## Appeal Decision

**Appeal Ref: APP/C3105/W/22/3295704**

**The Pheasant Pluckers Inn, Street through Burdrop, Banbury, OX15 5RQ**

SKETCHED VIEW FROM STREET THROUGH BURDROP

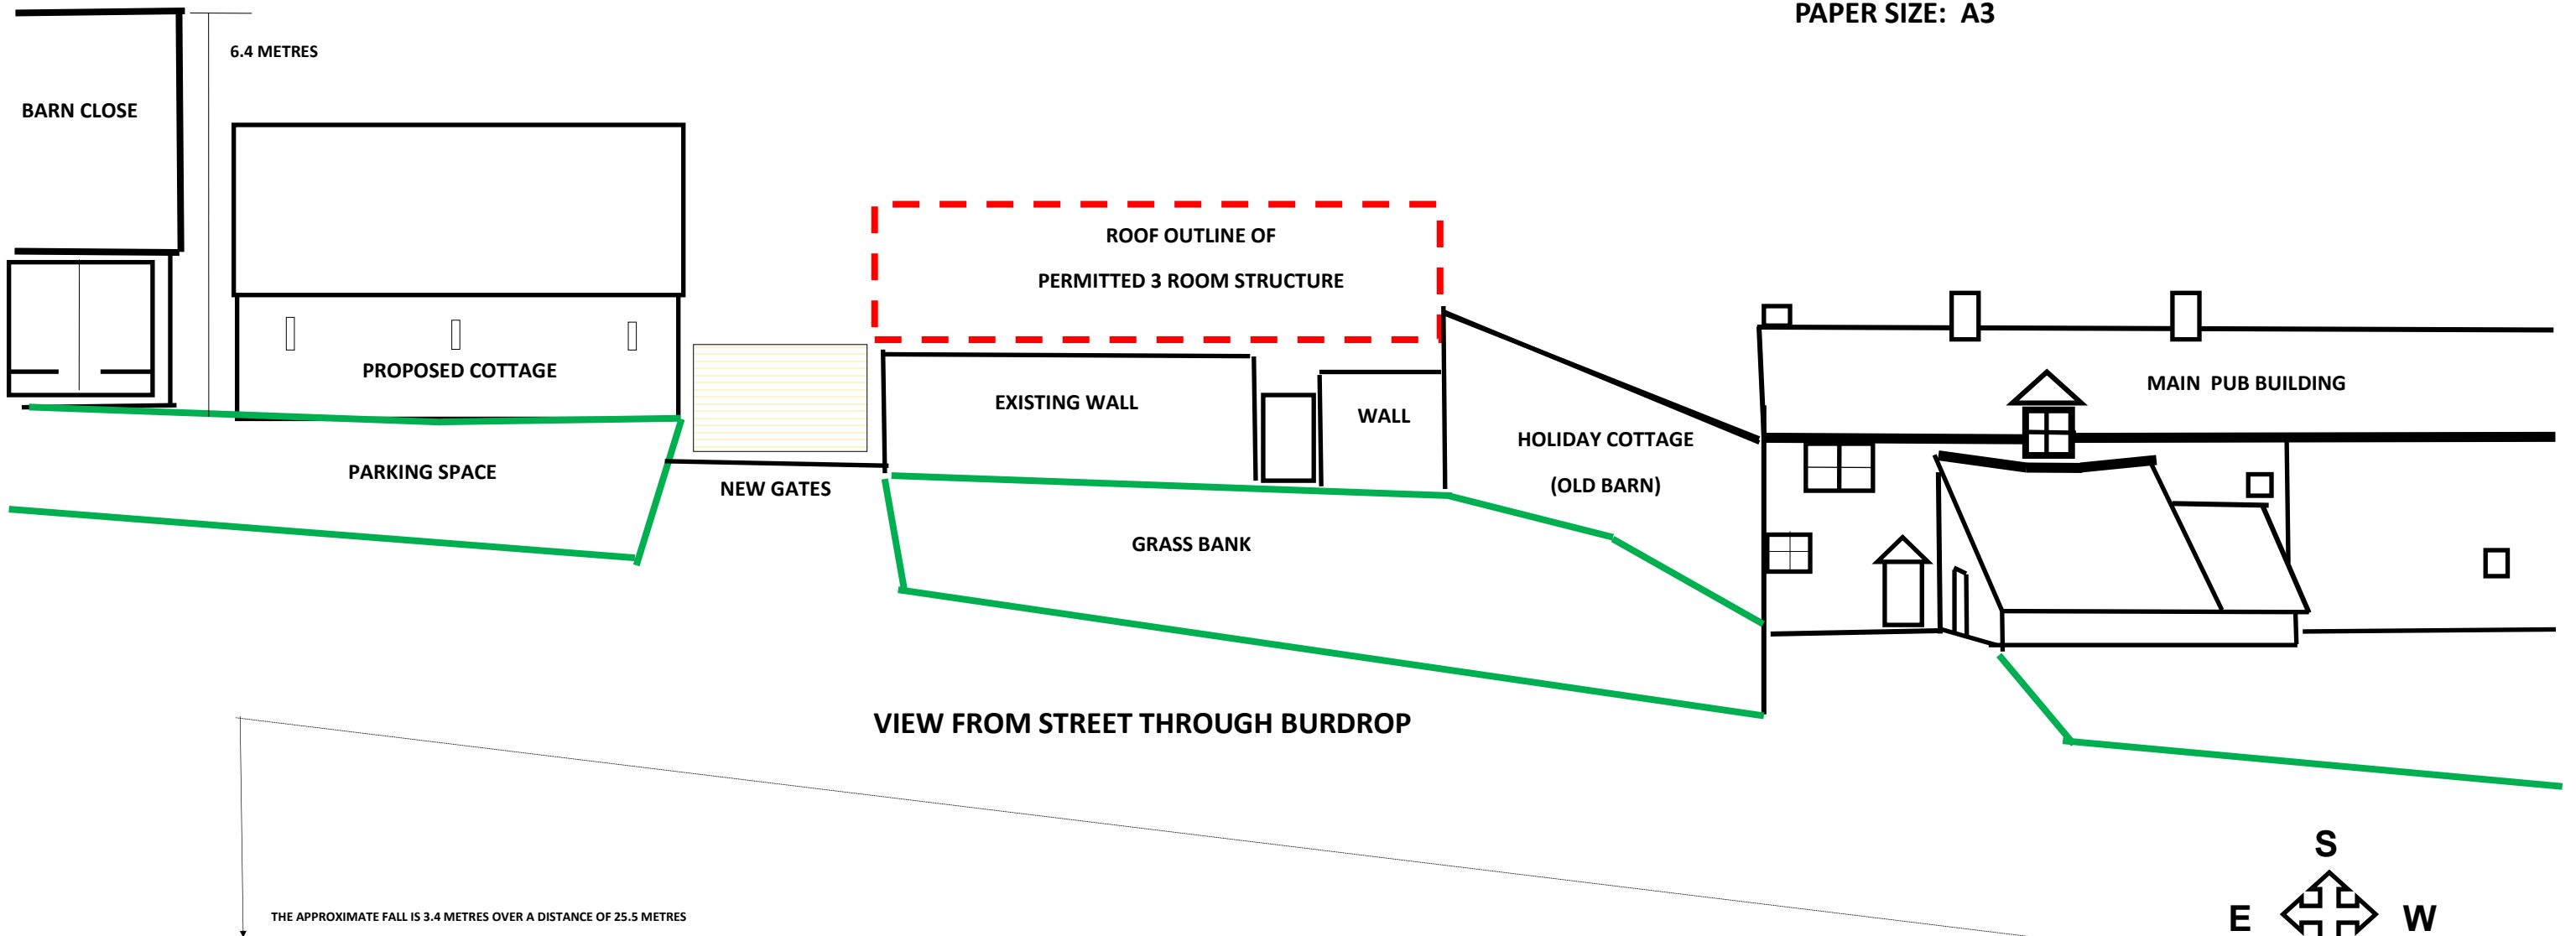
14. I could see that incorporating the random stone from the existing perimeter wall into the new build would follow similar developments located within close range. The stepped ridgeline would correspond with the adjacent buildings as land levels fall down the hill towards Hawk's Lane. Both parties agree that the use of stone wall and roof that would form the elevation to the street scene would be appropriate. I have no reason to disagree with this finding.

16. The proposal would be considerably smaller in scale and mass to those habitable buildings at Barn Close. The proposal in a broadly speaking 'L' shape, would take on the characteristics of a squat form of development. Its discordant appearance would be made more severe by the ridgeline height that would continue throughout. It would not successfully relate to a typical barn style dwelling made more incongruous when viewed in the context of the adjacent barn. Furthermore, the appellant's use of photographs of example sites are limited as comparisons as I have been provided with no background information or context to them. In any case, I have considered it within its individual context.

17. Its poor design articulation would be further heightened by the uncharacteristically wide dormer windows proposed to the roof plane. Dormer windows are evident to the farmhouse at Barn Close. Nevertheless, these are proportionate to the size of the roof and appear subservient in character.

20. This scheme would be smaller in width to that of the extant permission. However, that scheme provides very basic functions. Even if I were to agree with the appellant that the proposal would be comparable in size, the extant scheme is more akin to the modest proportions of a stable building. The scheme before me would be of very different design characteristics and a very different shape. It would appear much more domestic in character than a traditional barn-style building. I find it would not amount to betterment within the street scene but instead adversely at odds with local character.
